**Byers Gill Solar – EN010139**

**Section 51 advice regarding draft application documents submitted by JBM Solar**

SHEET 1 OF 13

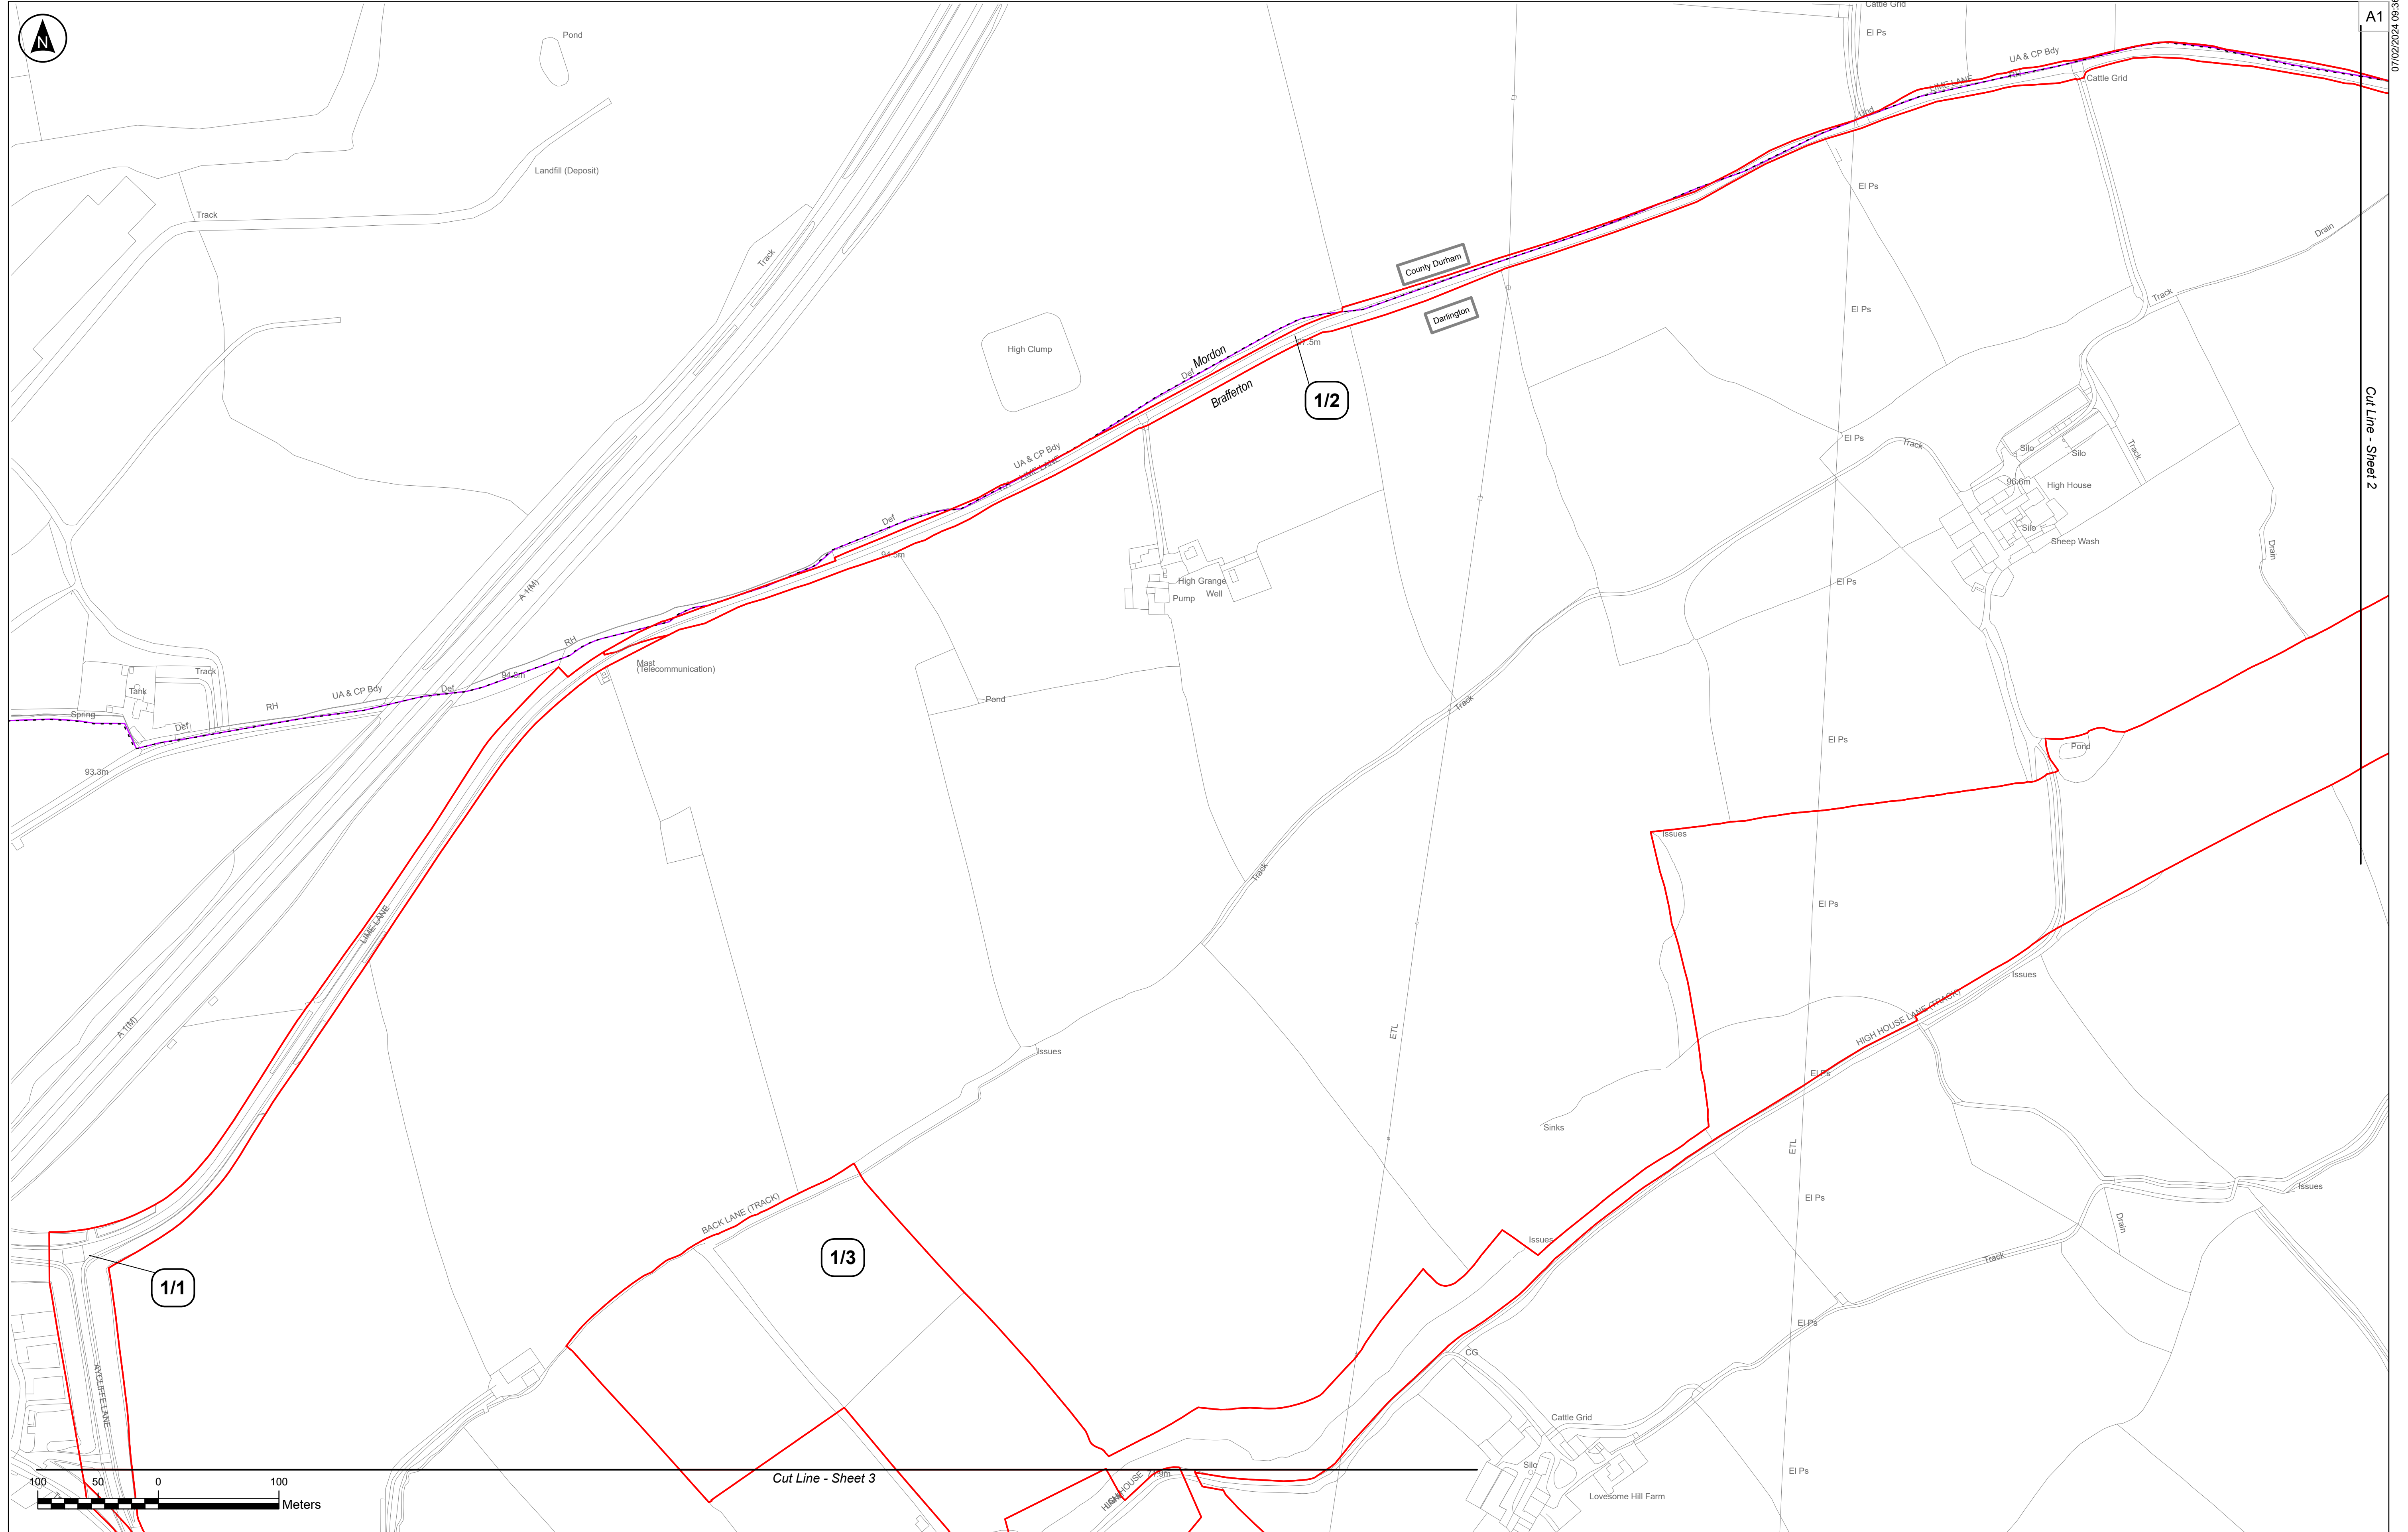
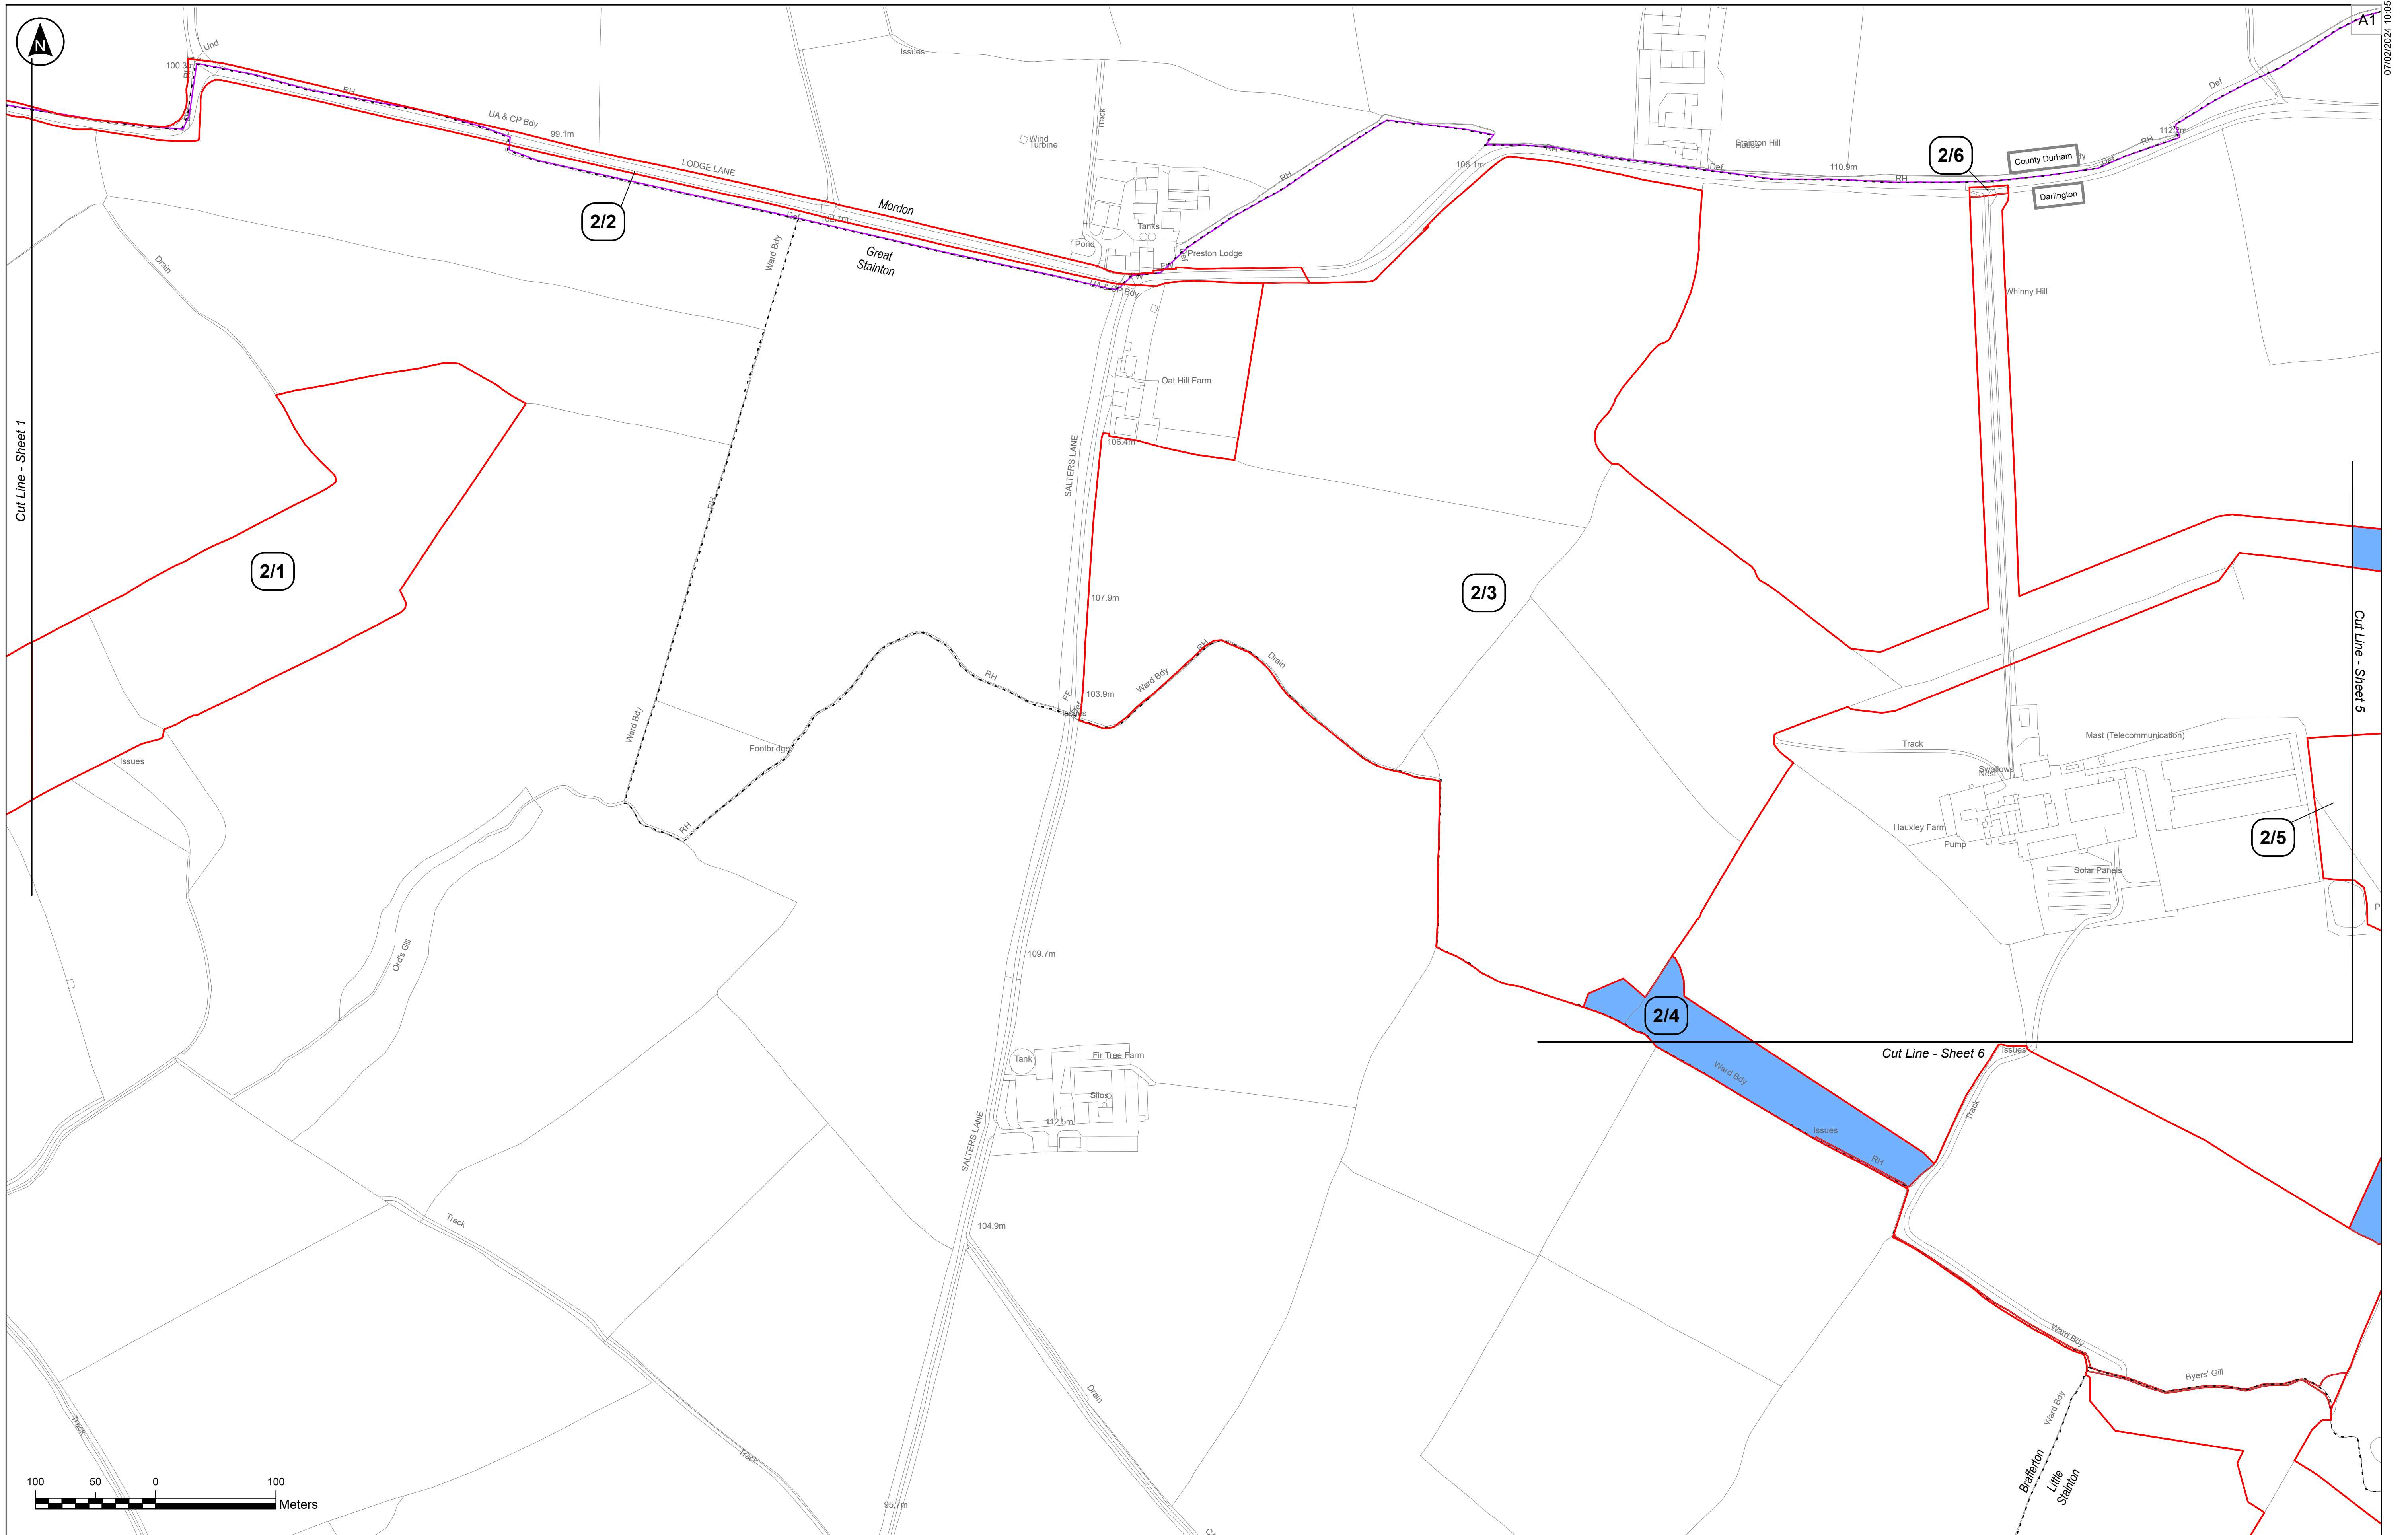
19.	<b>Key plan and Sheets 1-13</b>	It is noticed that both the overall key plan and the associated individual sheets state their scale as being 1:2500 at A1. The Land Plan Sheets and the Key Plan are clearly at different scales, and this brings into question the scale of the Land Plan and compliance with The Infrastructure Planning (Applications: Prescribed Forms and Procedure) Regulations 2009 (APFP 2009) Regulation 5 (4A). It appears likely the Key Plan is incorrect in its quoted scale. The Inspectorate would like to remind the Applicant that such inaccuracies reduce confidence that any or all stated information is accurate.

Land Plan		
Ref No.	Plan ref	Comment/Question
		The Applicant may wish to check the scales of the sheets of the plan provided and ensure that the scale is correctly stated on each sheet.
20.	<b>General and Part 5 of the dDCO</b>	<p>It has been noticed that the draft Development Consent Order refers to all land within the order limits being within the scope of Compulsory Acquisition powers, but this is not what is shown in the Land Plan, which most of the land appears to have been shaded in conformity with the legend entry for land that is not subject to compulsory acquisition. This could cause confusion as this does not appear to be consistent.</p> <p>The Applicant may wish to review this point and ensure that there is consistency between different documents and clarify the position in relation to Compulsory Acquisition powers.</p>
